**Attachment D:**  
**Hyak FPUD Amended Compliance Review Matrix -**  
**April 24, 2018**

**Hyak PUD Amended Compliance Review – UPDATED April 24, 2018**

Planned unit development of originally 650 units and then reduced to 622 units, now 392 units mixed between multi (344) and single family (48). Project received preliminary approval on January 18, 1994. Resolution No. 94-12.

DEVELOPMENT, STORMWATER AND PARKING PLAN - PARCEL A

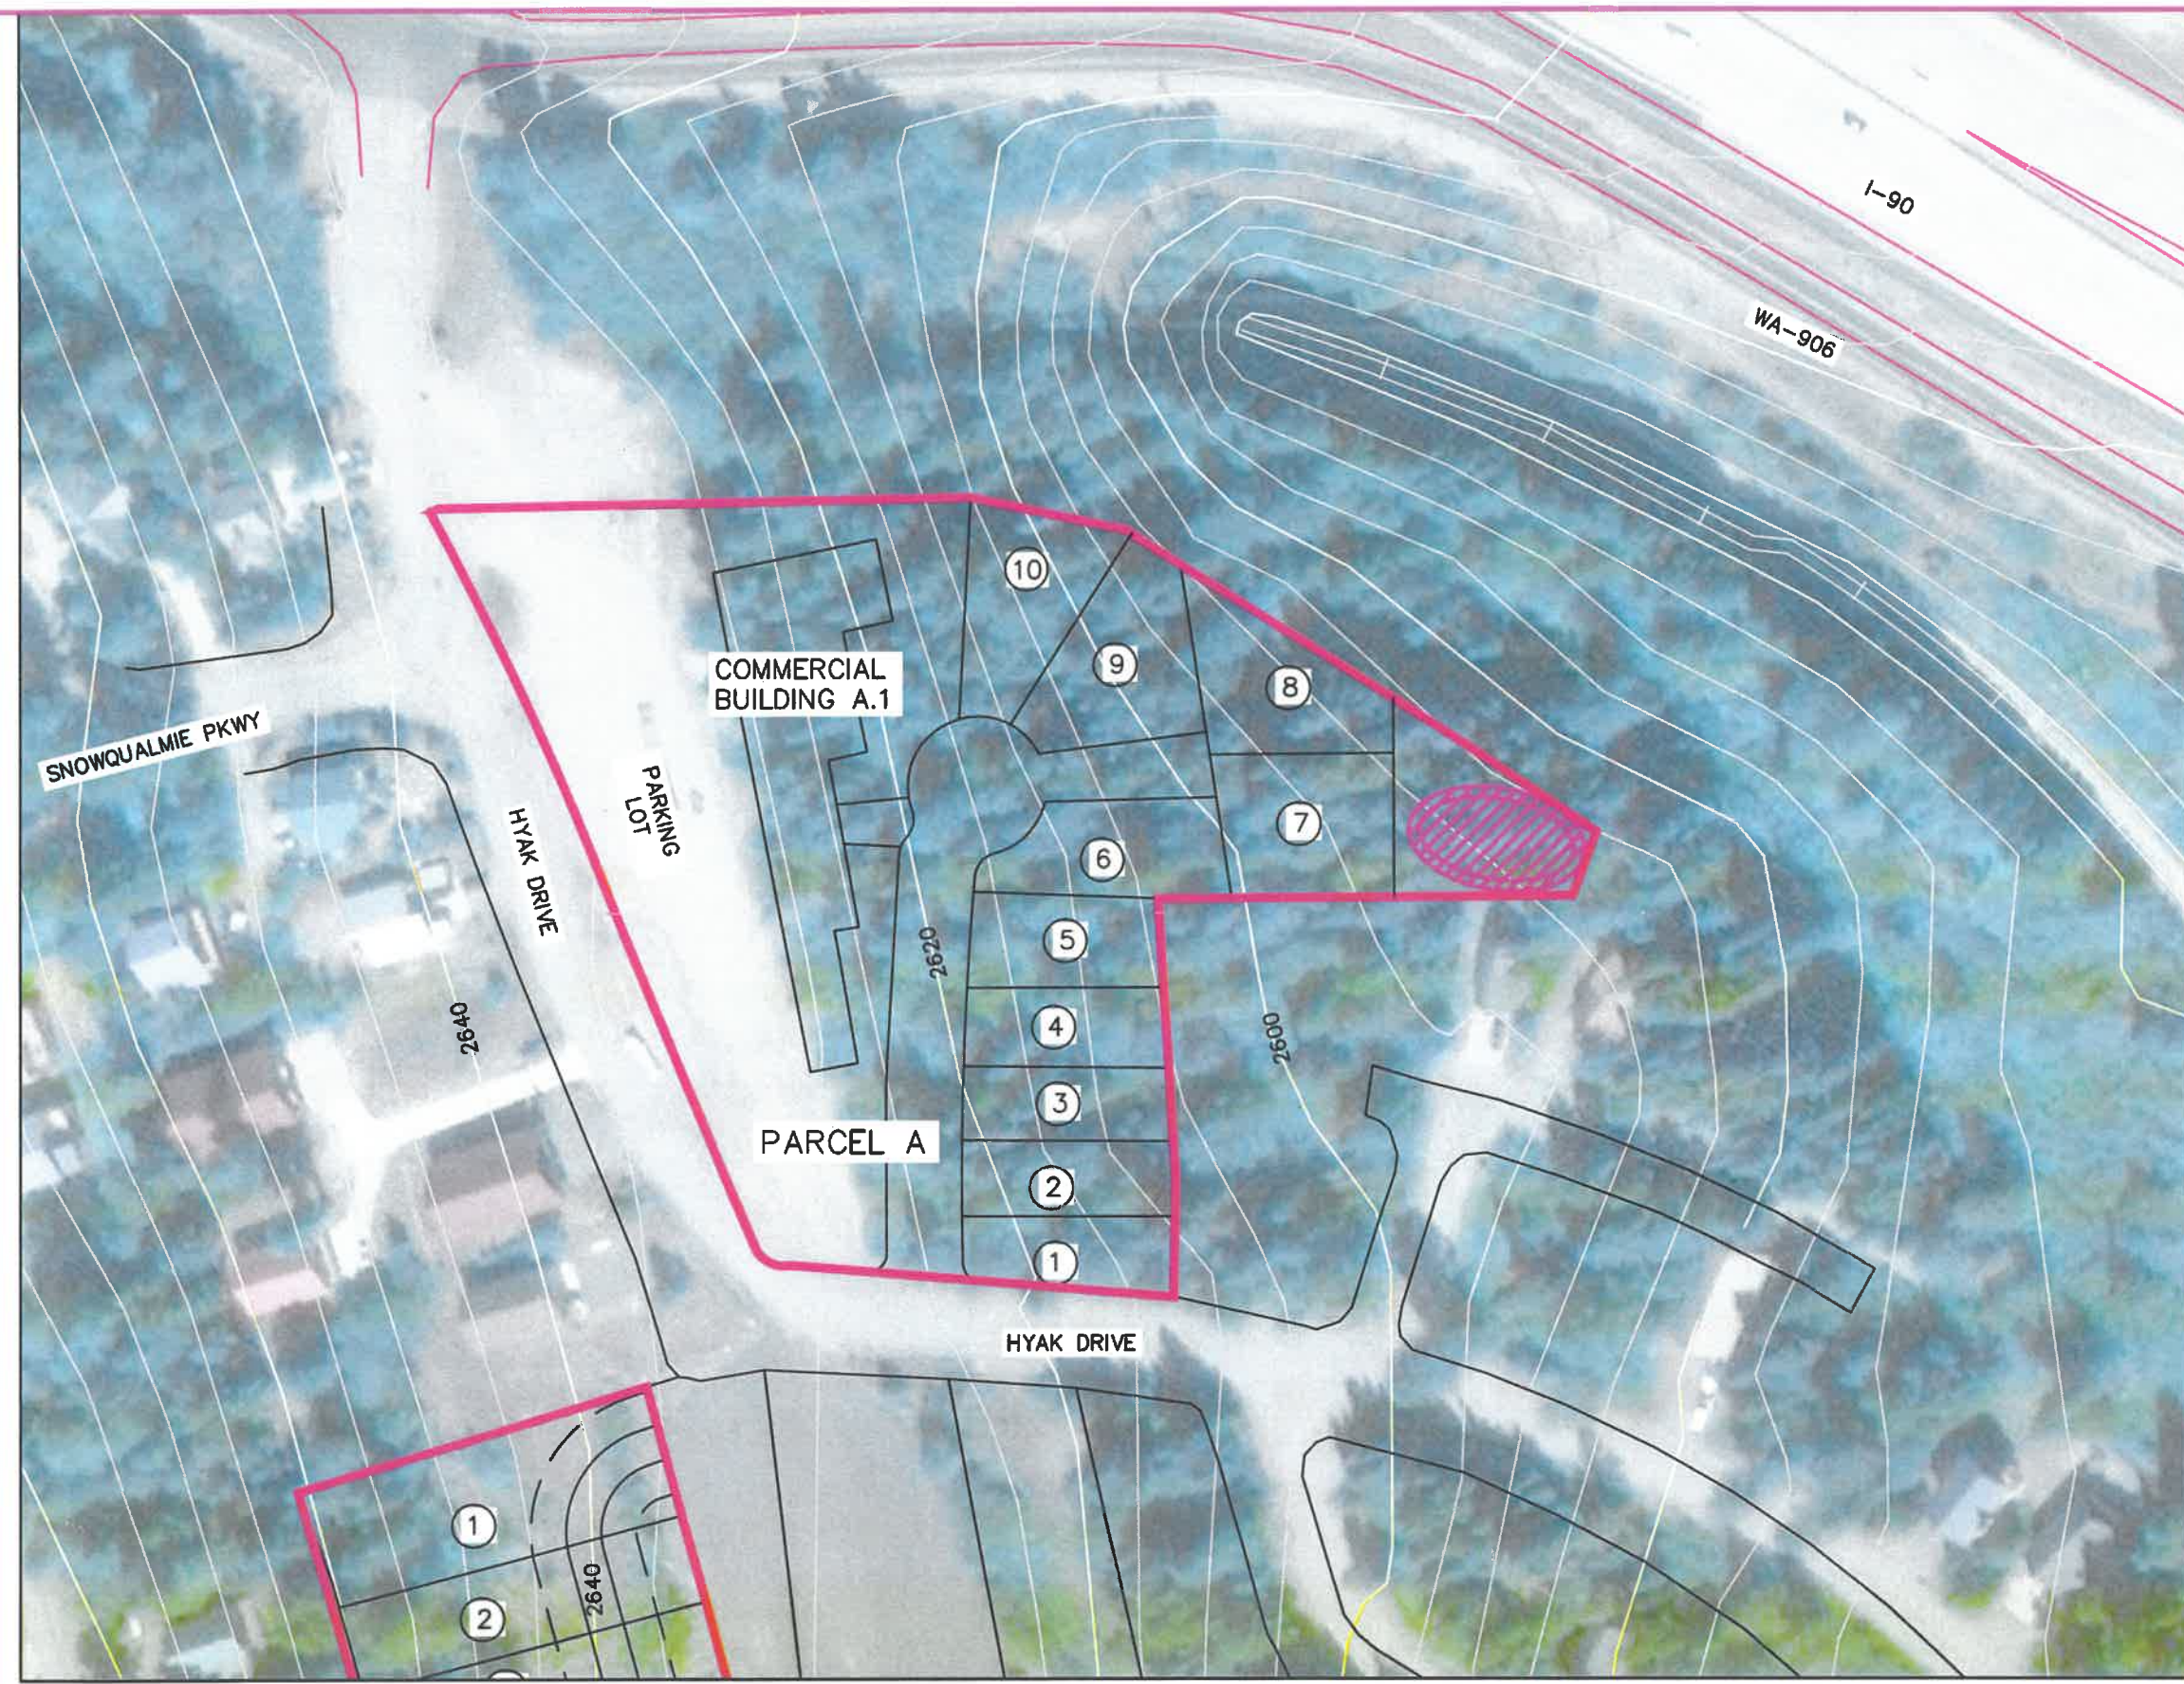
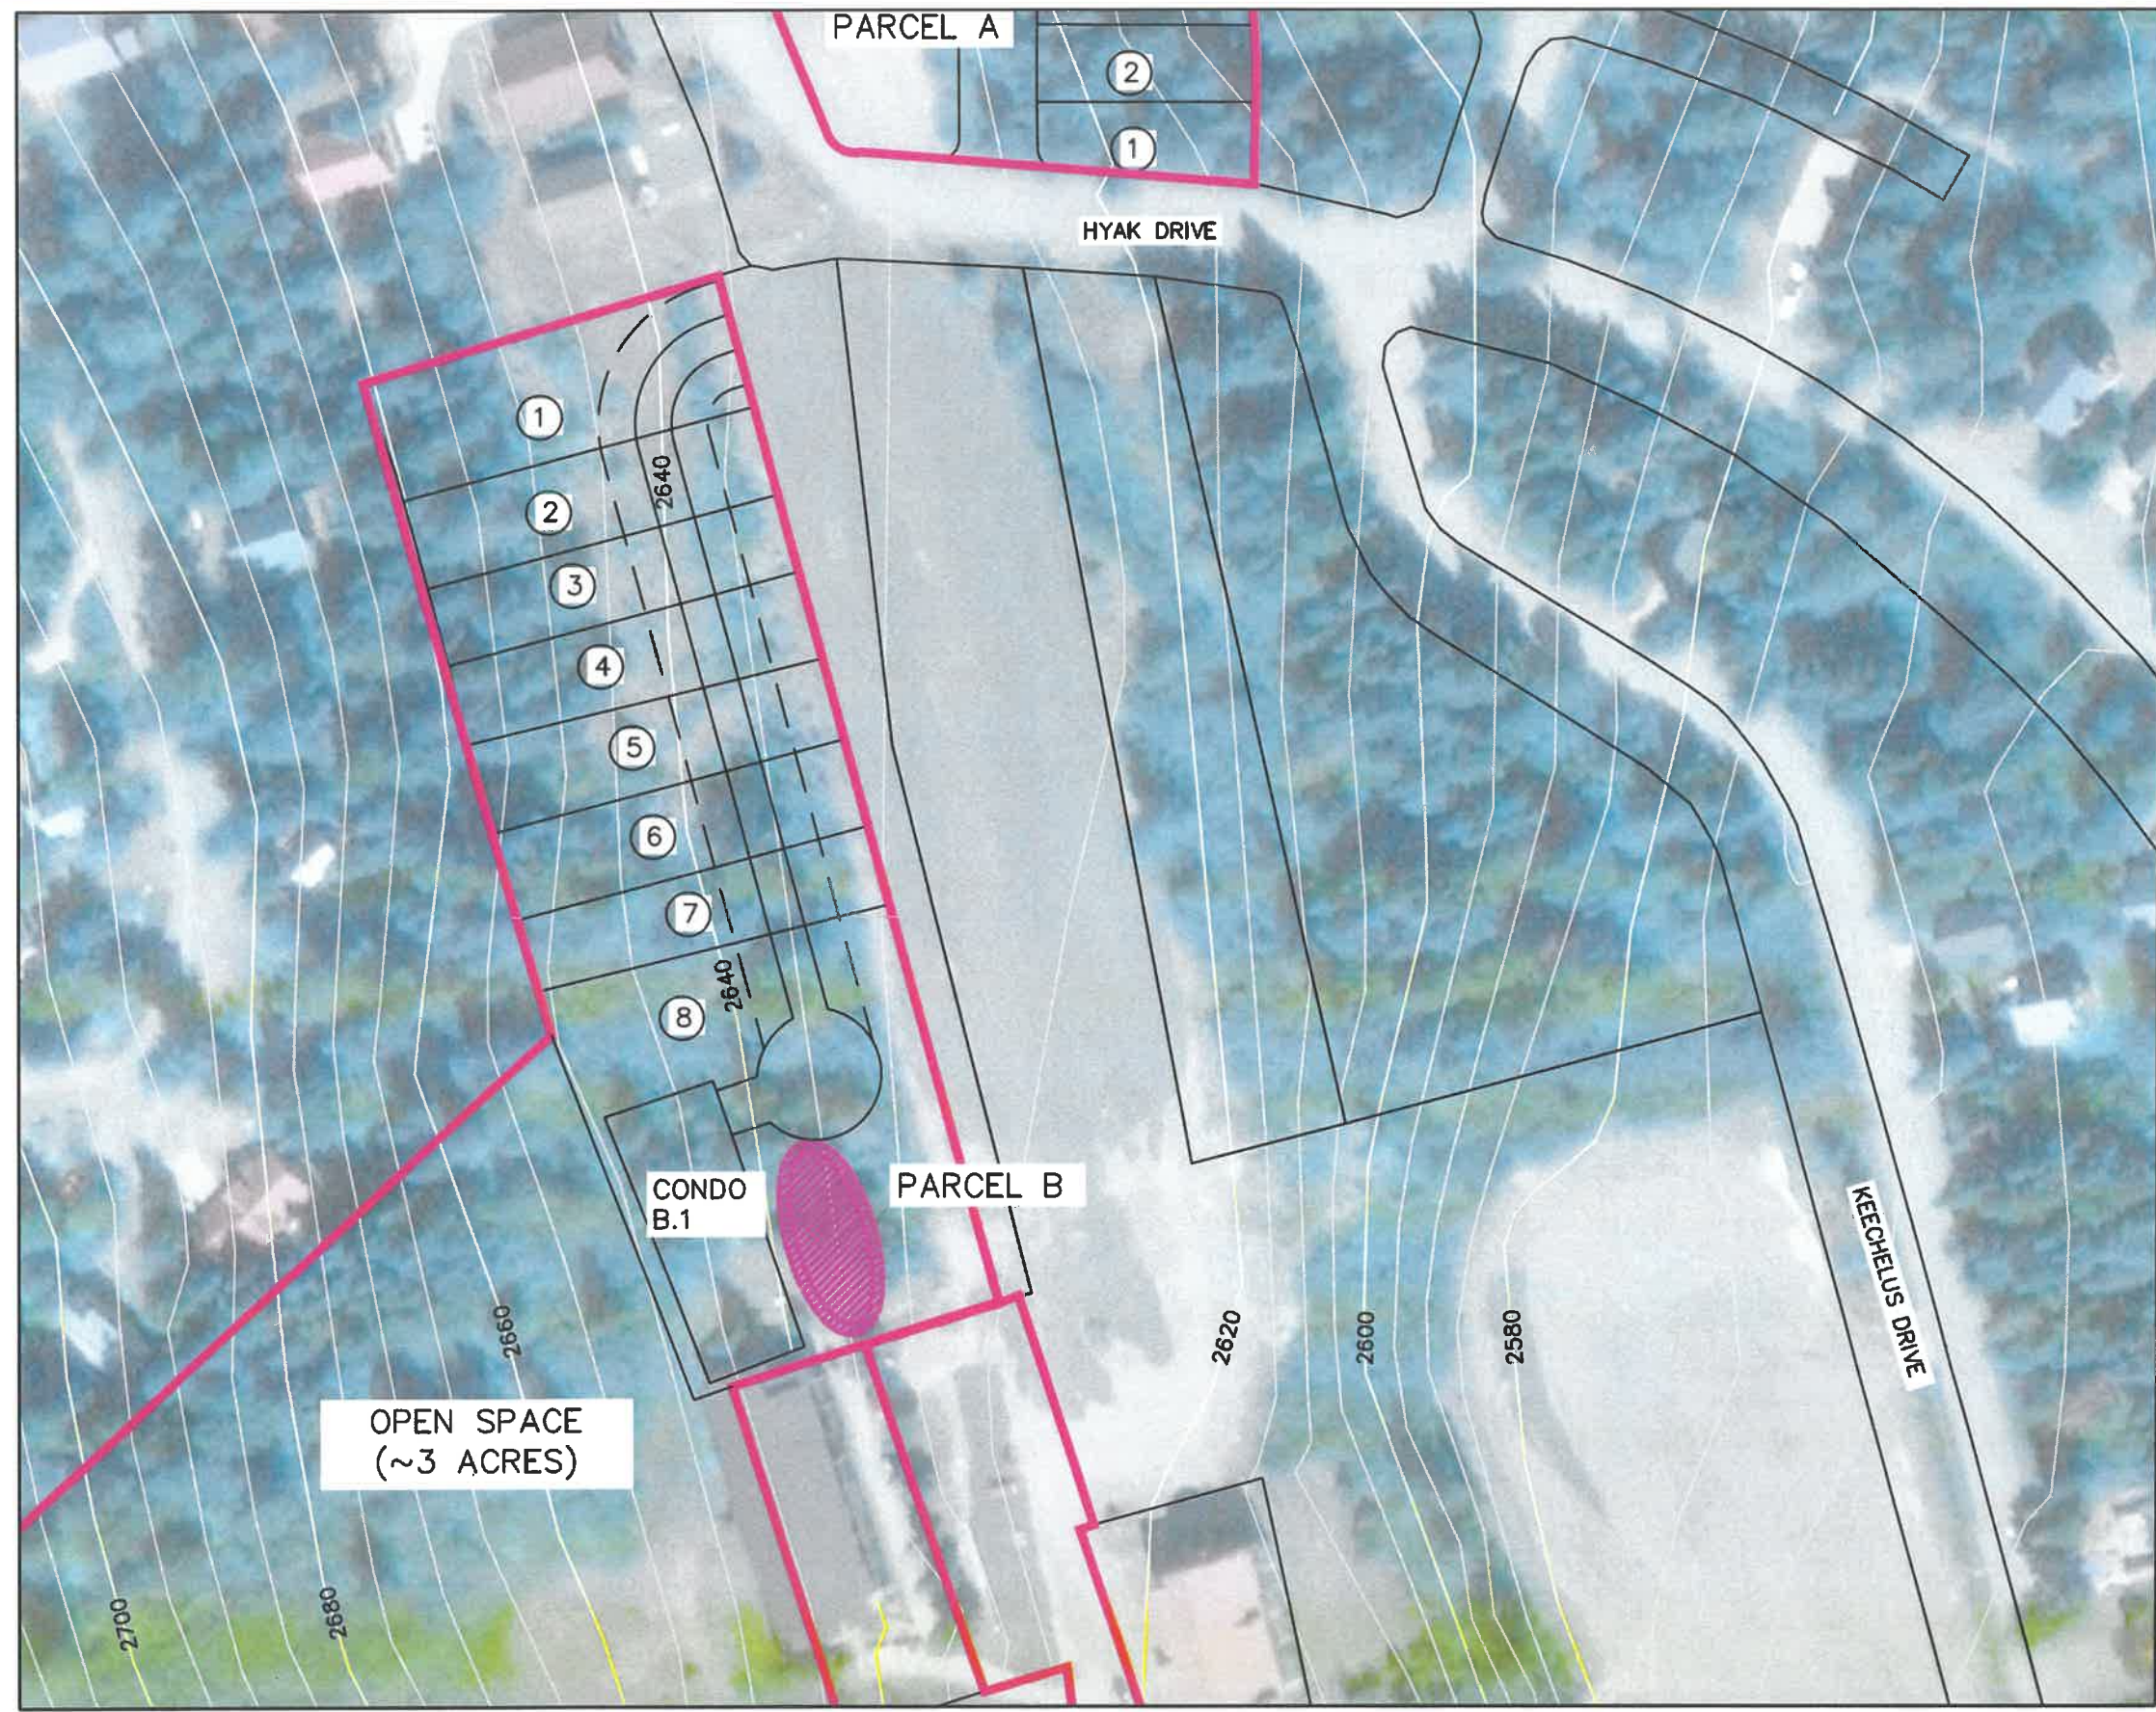
B.13	Along with the final development plan, a definitive parking plan shall be submitted providing a parking density of 1.5 parking spaces per multi-family unit. Parking space or stall dimensions shall be approved by the County Engineer.	The application provides for one (1) parking space per condo unit, needs to be 1.5 per unit at minimum per approval condition and Public Works memo. Applicant shall address. New parking plan and explanation submitted on February 15, 2018. <b>(Index 23 &amp; 28 of Master File)</b>	<b>Satisfied</b>
